CITY OF ALBUQUERQUE

May 2, 2008

**Re: Isleta Church of Christ Addition, 2424 Miles Road SE (M16-D40),
Traffic Circulation Layout
Engineer's Stamp Dated 4-18-08 (M16-D40)**

SITE PLAN

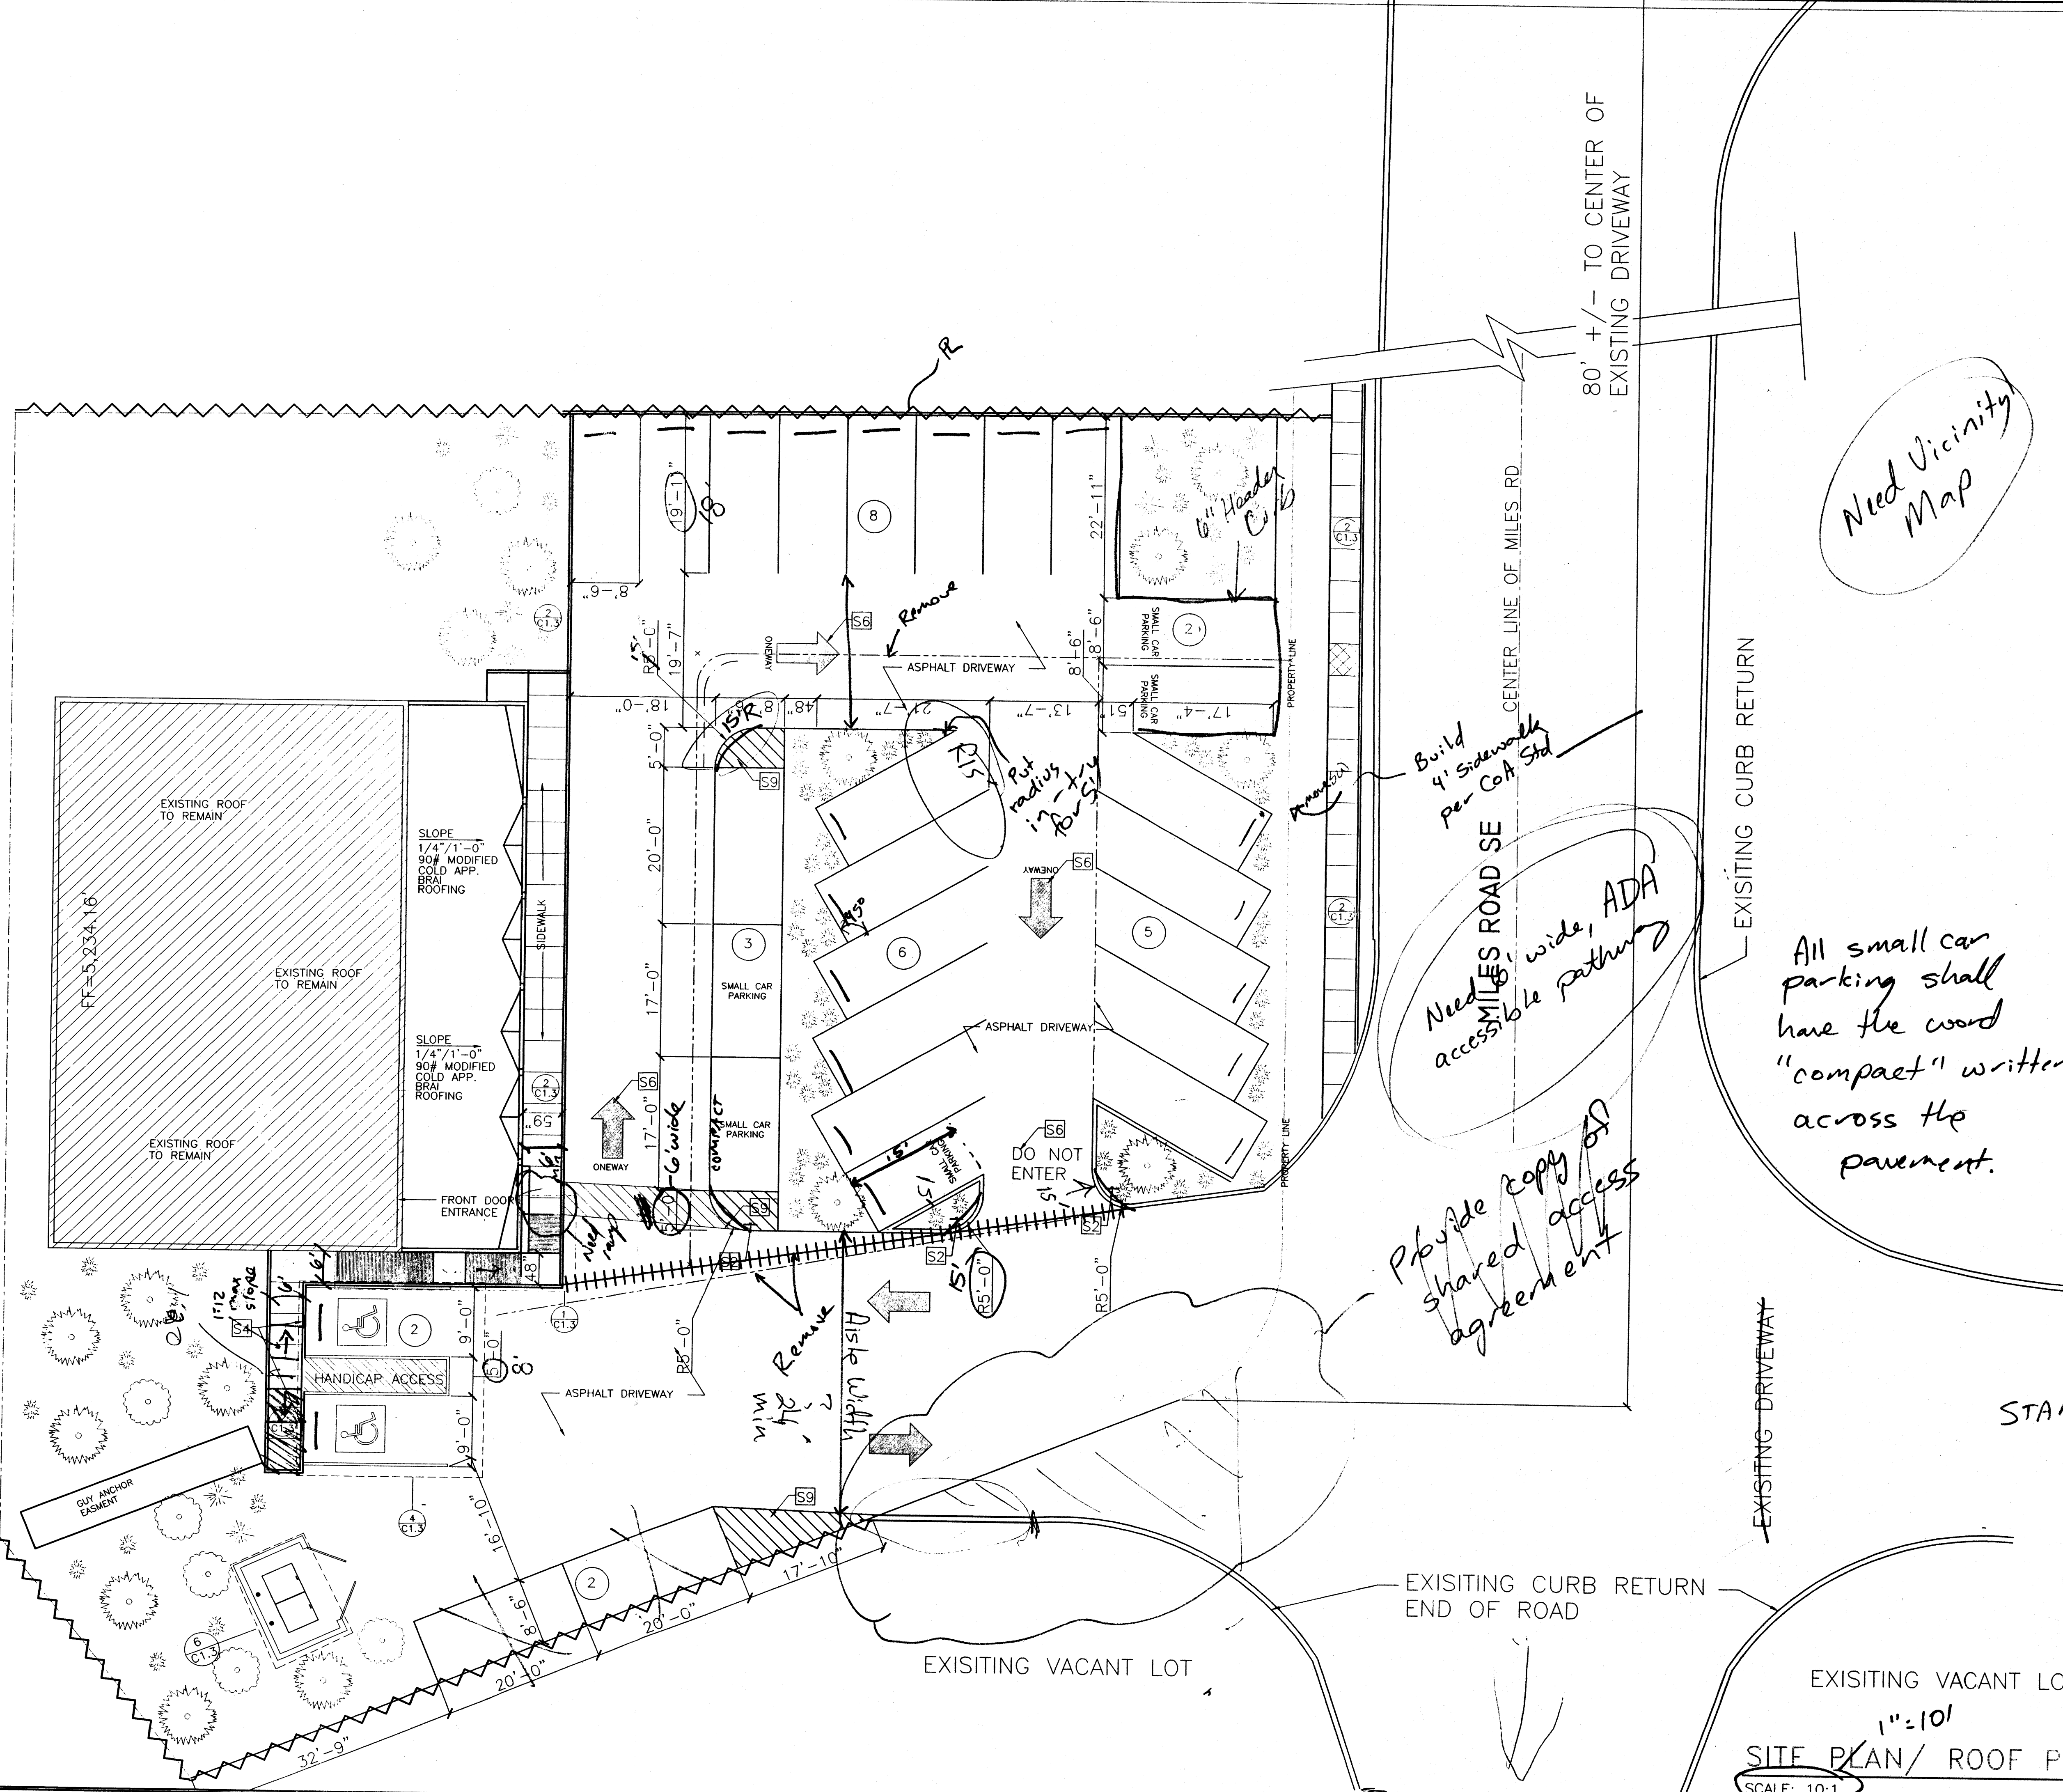
- The spot elevations shown on this plan will create ponding in the parking lot since some of them are almost 3 feet below Miles Rd.
- The plan does not provide adequate water blocks at the entrances to ensure that runoff in Miles stays in the road.

- On the western edge of the parking lot, it appears that 5 feet of fill will be needed. Is a retaining wall planned? This should be shown on plan and concurrence from the electric company will be required since there will be much less clear distance to the electric lines shown on your plan.

- The plan shows existing curb that must be removed (no note to that effect) and, more importantly, new curb that must be built in Miles. As you are aware, this curb must be built by City Work Order. It is not apparent what the extents of this curb would need to be to keep runoff from the north and east from entering your site.

- Please quantify any offsite runoff entering your site from the south and east.

1. Please clarify the existing versus proposed conditions.
2. Show the lot lines on the plan.
3. Is the proposed entrance a drivepad or curb return? Your build note indicated this entrance has curb returns.

4. Demonstrate how the existing exit meets current ADA standards.
5. List radii for all curves shown.
6. Provide a clear vicinity map showing the location of the development in relation to well-known landmarks, municipal boundaries, and zone atlas map index number.

7. For passenger vehicles, the minimum end island radius is 15 feet.
8. What is the distance between drivepads? Please provide this information.
9. Please show the location of the nearest driveway on the adjacent lots.

10. A five-foot keyway is required for dead-end parking aisles.
11. List the number of parking spaces required by the zoning code as well as the proposed number of parking spaces.

12. The parking stalls must be separated from traffic flow by a curbed or striped end aisle a minimum of 4 feet in width.
13. Is the sidewalk along Miles Road existing or proposed? If proposed, the sidewalk must be located at the property line.

14. Please include two copies of the traffic circulation layout at the next submittal.
15. As the proposed traffic circulation includes one directional traffic, appropriate striping and signing must be provided ("Do Not Enter" signs, striping, etc.).

16. Call out the width of all sidewalk, both existing and proposed. Note where sidewalk width narrows and provide the width in this area.
17. Provide geometric details for the wheelchair ramps. Include slope.
18. Build notes are needed for the proposed drivepads. Provide details or refer to the appropriate City Standards.
19. Please refer to all applicable city standards by City Standard number.
